From: Darren Kennett - TW Southern Counties [REDACTED]
Sent: 16 August 2019 14:51
To: Ian Gledhill <[REDACTED]>
Cc: Karen Garner [REDACTED]
Subject: RE: AL/50/19/DOC - Condition 12 - Secure Cycle Parking - Nyton Nursery

Subject: AL/50/19/DOC - Condition 12 - Secure Cycle Parking - Nyton Nursery

APARTMENT BLOCK
SECOND FLOOR
PLAN

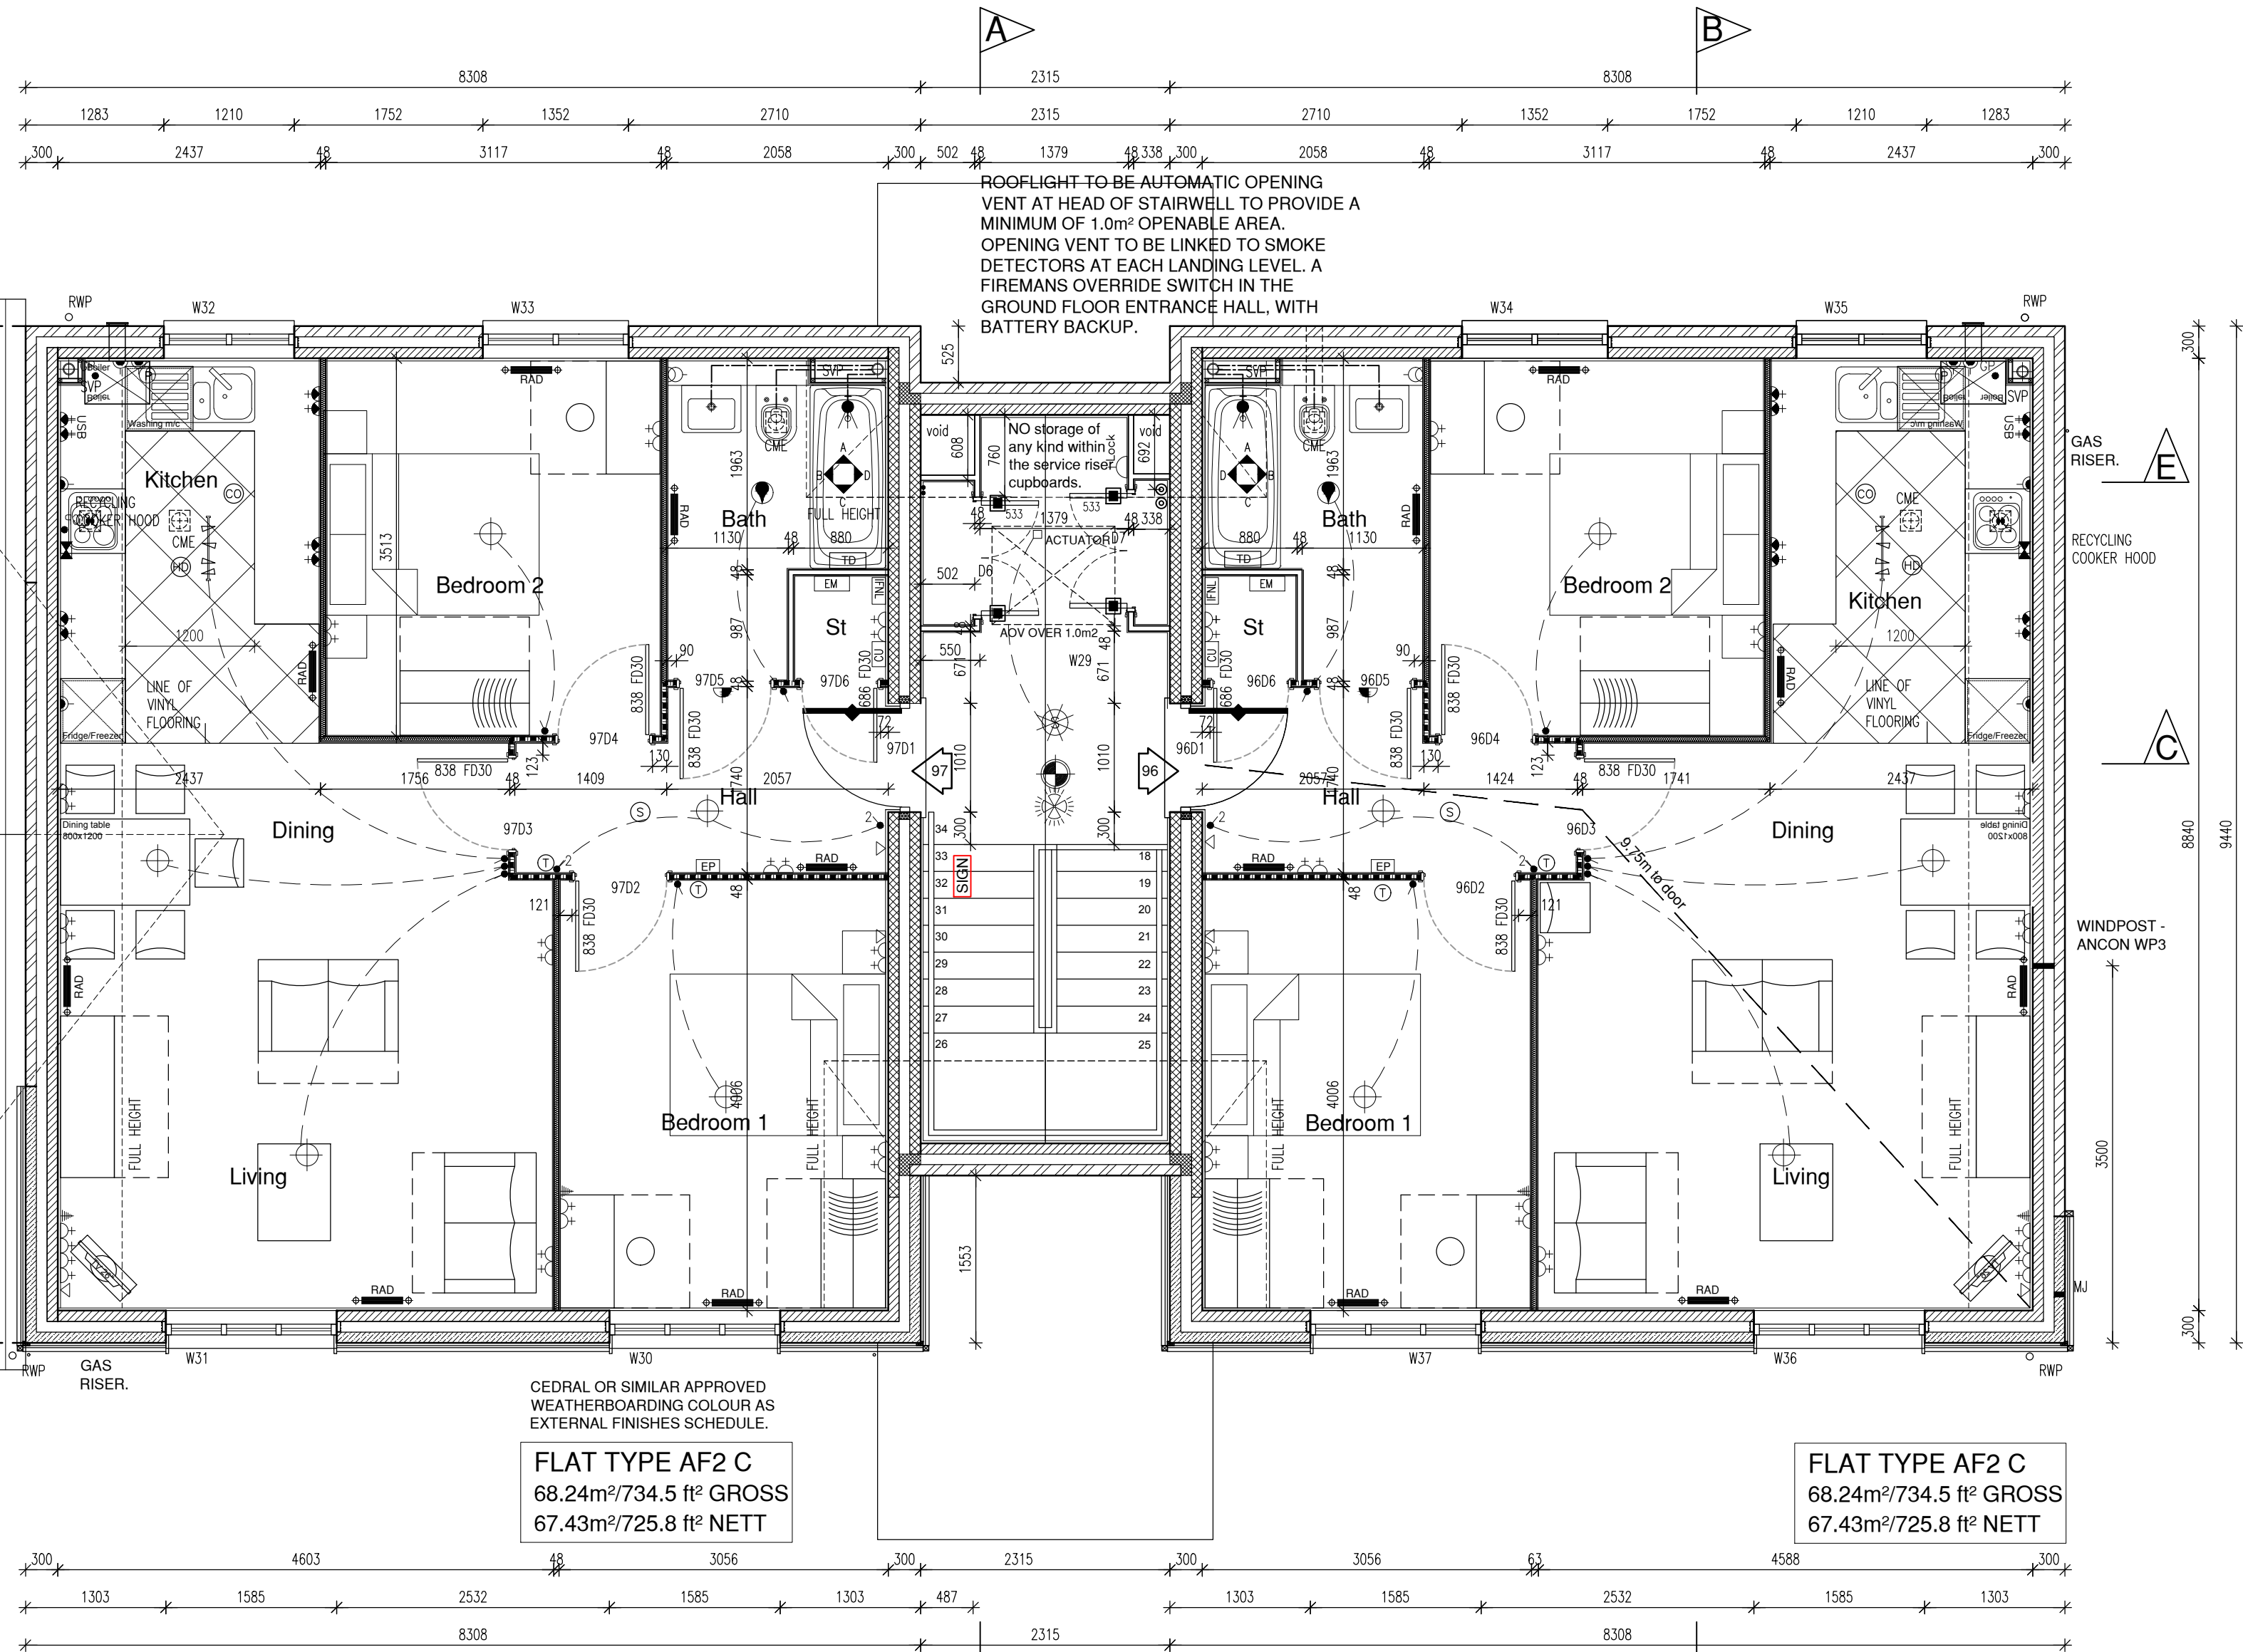
Hello Darren, thanks for this. Can I just check that this is the correct drawing? It seems to show only the second floor layout of the flats.

Sorry, try this one.

APARTMENT BLOCK
GROUND FLOOR
PLAN

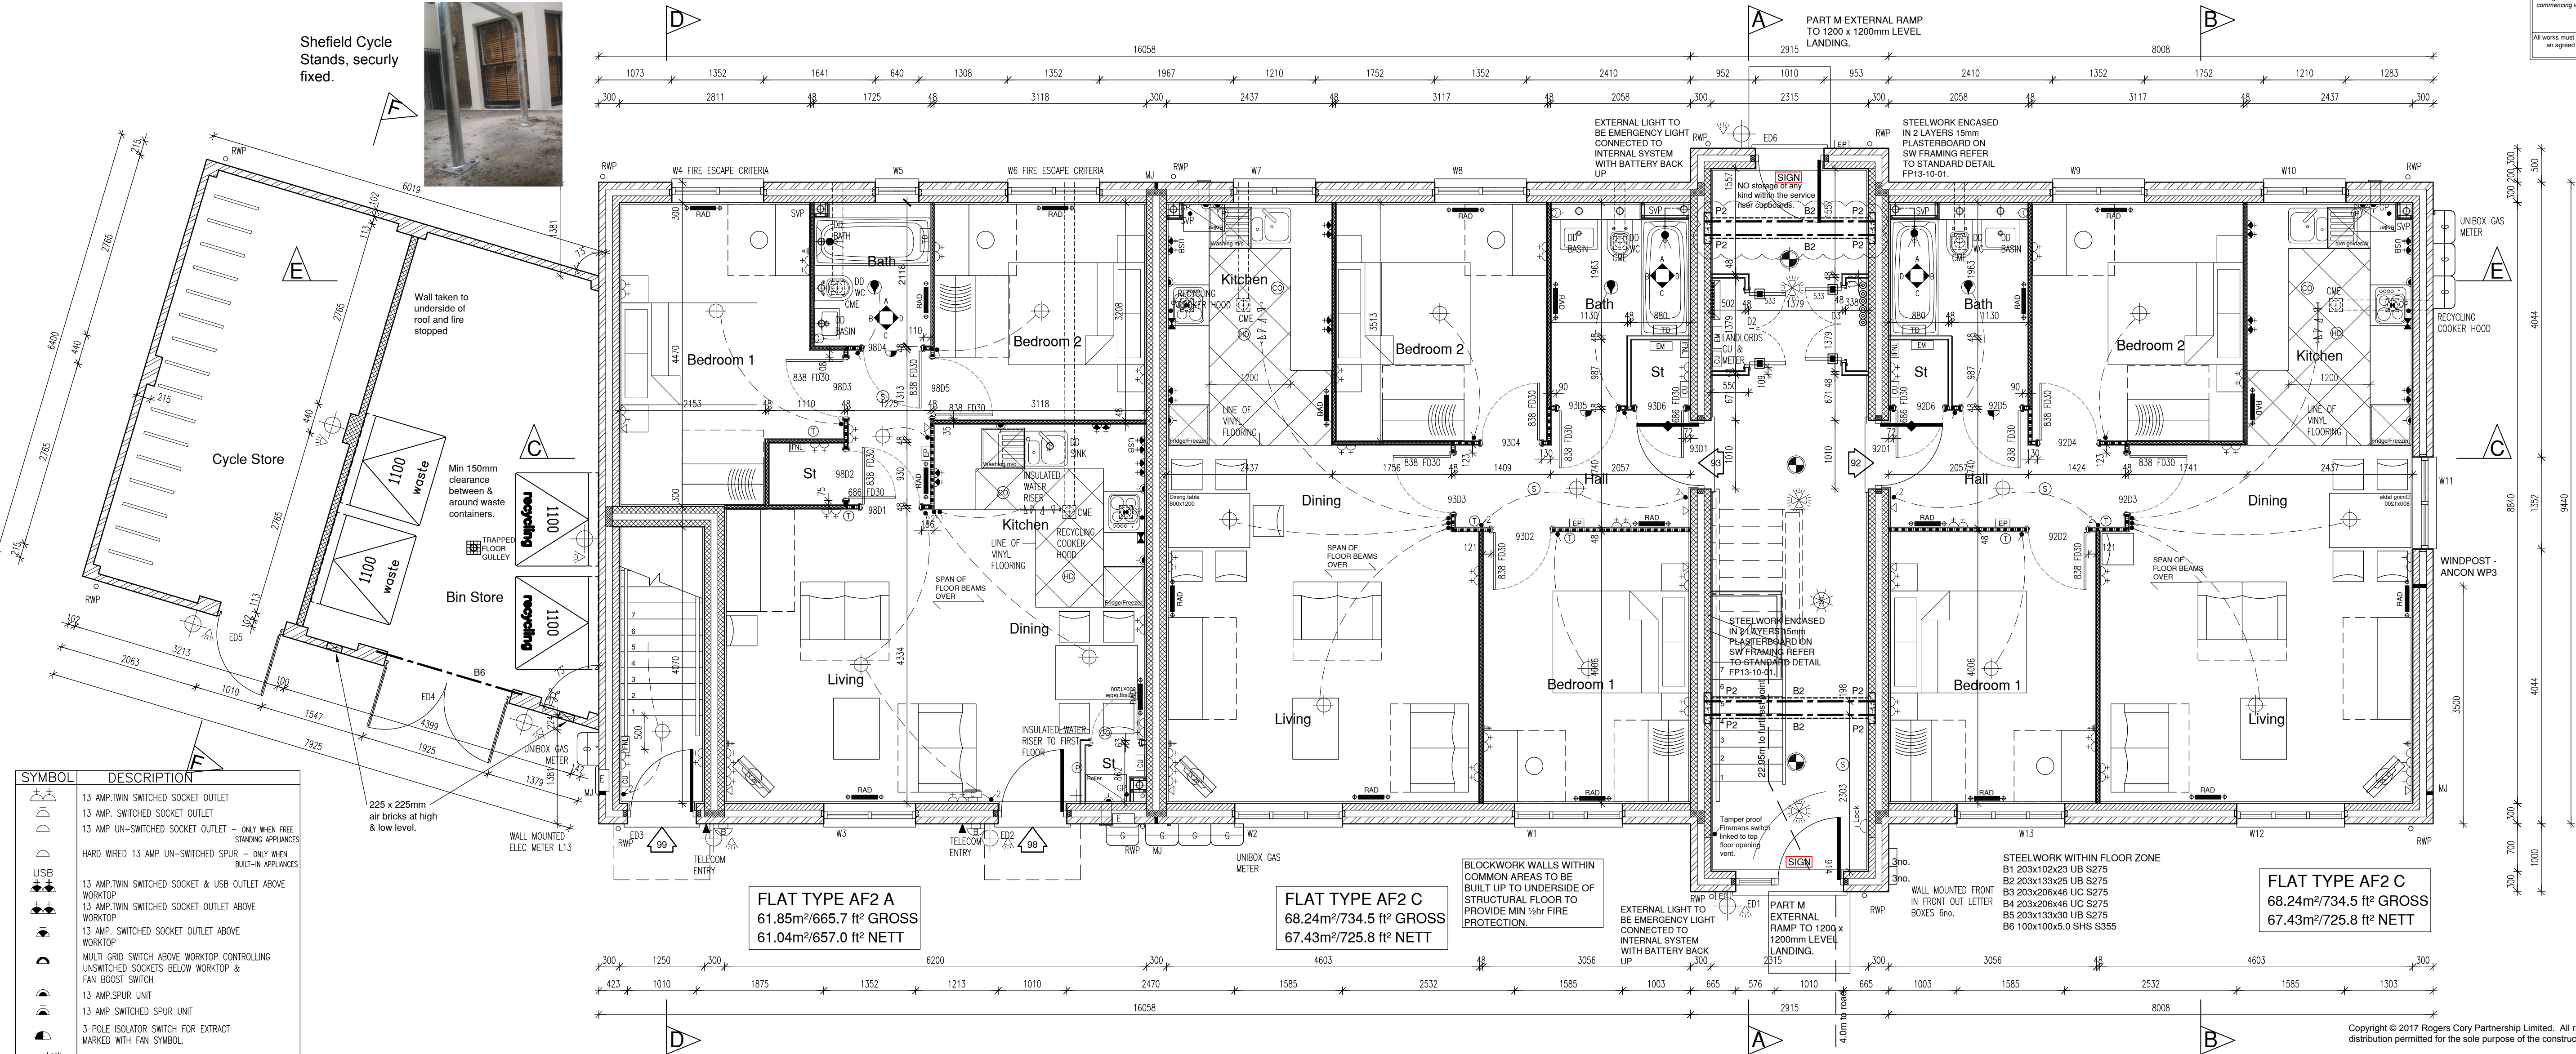
I've just reviewed the feedback concerning the cycle storage provision on our scheme.

We shall be installing Sheffield Cycle stands, which will be securely fixed to the floor.

The apartment plan is attached and I have added a photo and note.
